Consultation Response from KC Waste Strategy (Refuse & Cleansing)		
PA no. & address: 2021/91506 Shop Lane, Kirkheaton, Huddersfield, HD5 0DB		
Proposal: Reserved matters application pursuant to outline permission 2014/92535 for erection of 48 dwellings, formation of access and associated infrastructure		
Date Responded: 11/05/2021	Responding Officer: Carol Oakden	Responding Ref: WPS-21-015

**SHOP LANE**

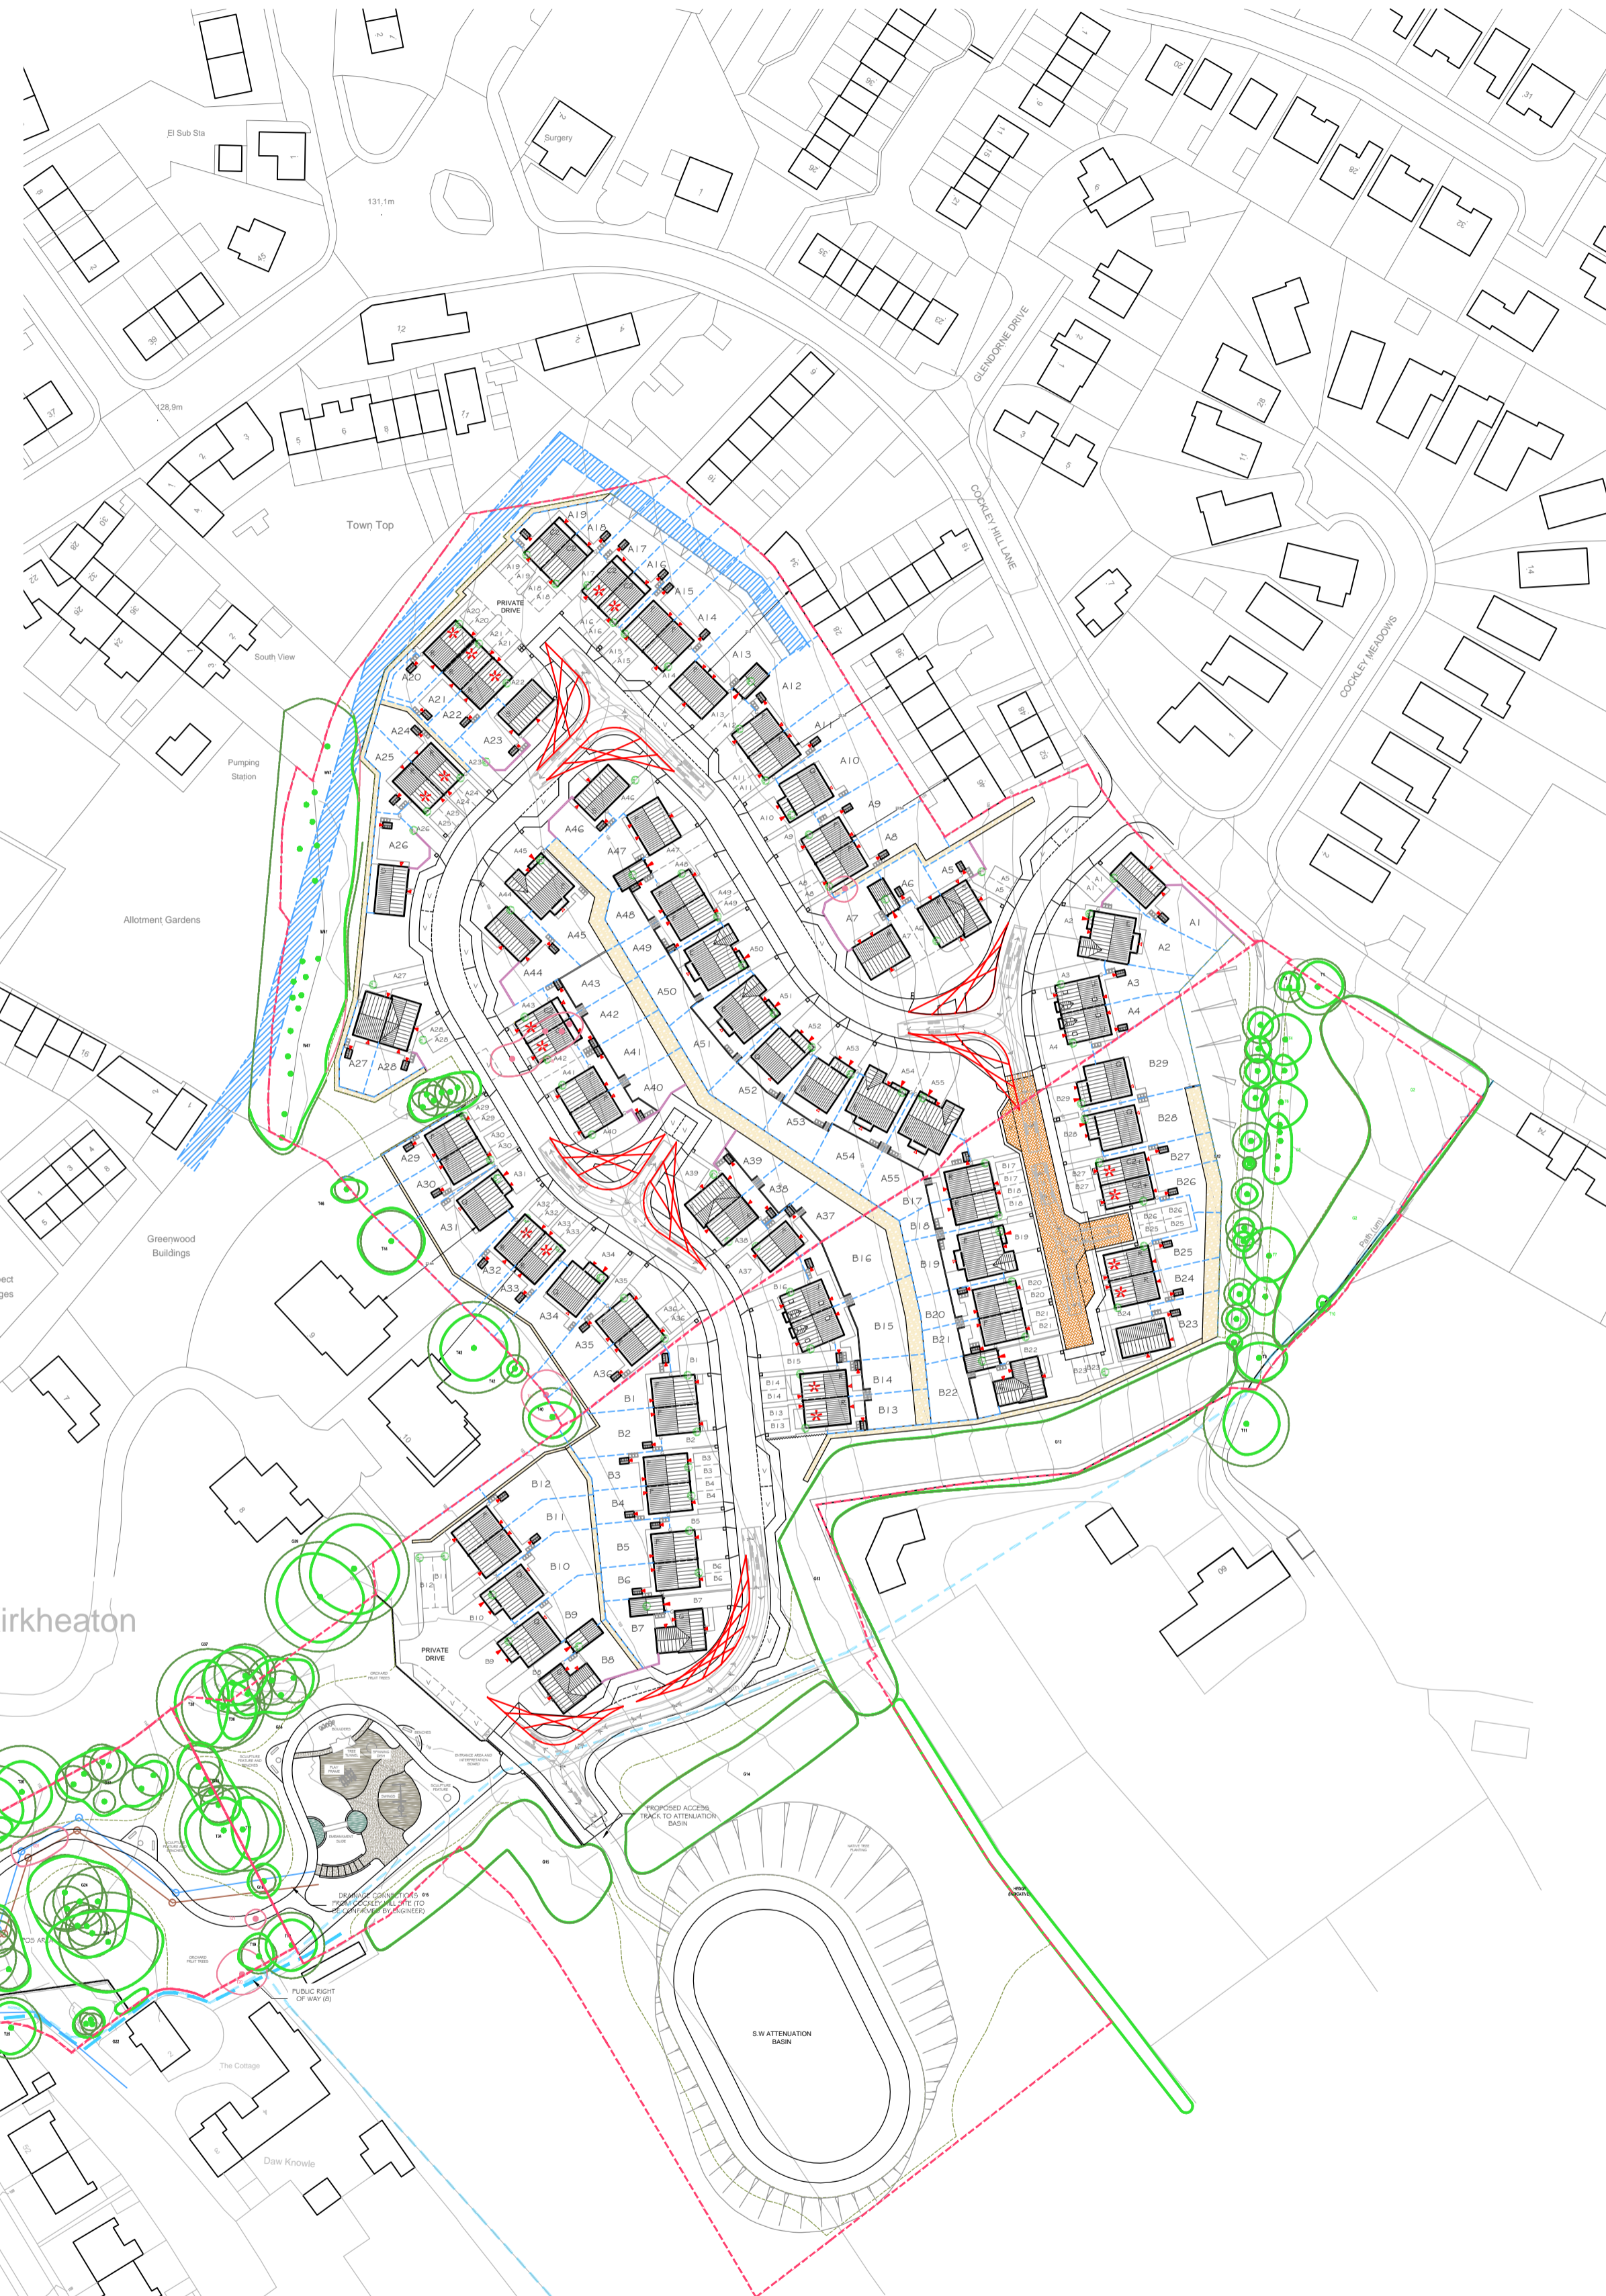
- The submitted layout (drawing number P09:4266:01F) does not include any indication of bin storage or collection points. Gated rear access exists to most plots, allowing for bins to be stored securely to the rear and avoiding bin blight to the front. However, the mid-terraced properties at plots 22 and 26 have convoluted rear access arrangements which are likely to encourage bins being left to the front of the properties. This introduces issues of bin blight in the street scene and increases the likelihood of odour issues close to windows/doors, unauthorised use, and theft/damage to bins. Secure screened storage to the front of these properties would help to tackle these issues.

- Plots 28-31 are shown as dwelling type A2 (flats over garages). These have shared integrated bin/cycle storage to the ground floor, accessible by double side access doors. These appear to be big enough to accommodate the minimum bins required for this type of property (2 x 240ltr bins per flat).

- There is likely to be a concentration of bins in the street on collection day around the turning heads outside plots 27-29 and 13-16. An off-street, suitably surfaced space to accommodate these would help to reduce the resulting obstruction to the highway and footways.

- A communal presentation point will be required for plots 1-3 as these are accessed via private drive. A suitable point adjacent to the main access road should be identified where bins can be presented without causing obstruction.
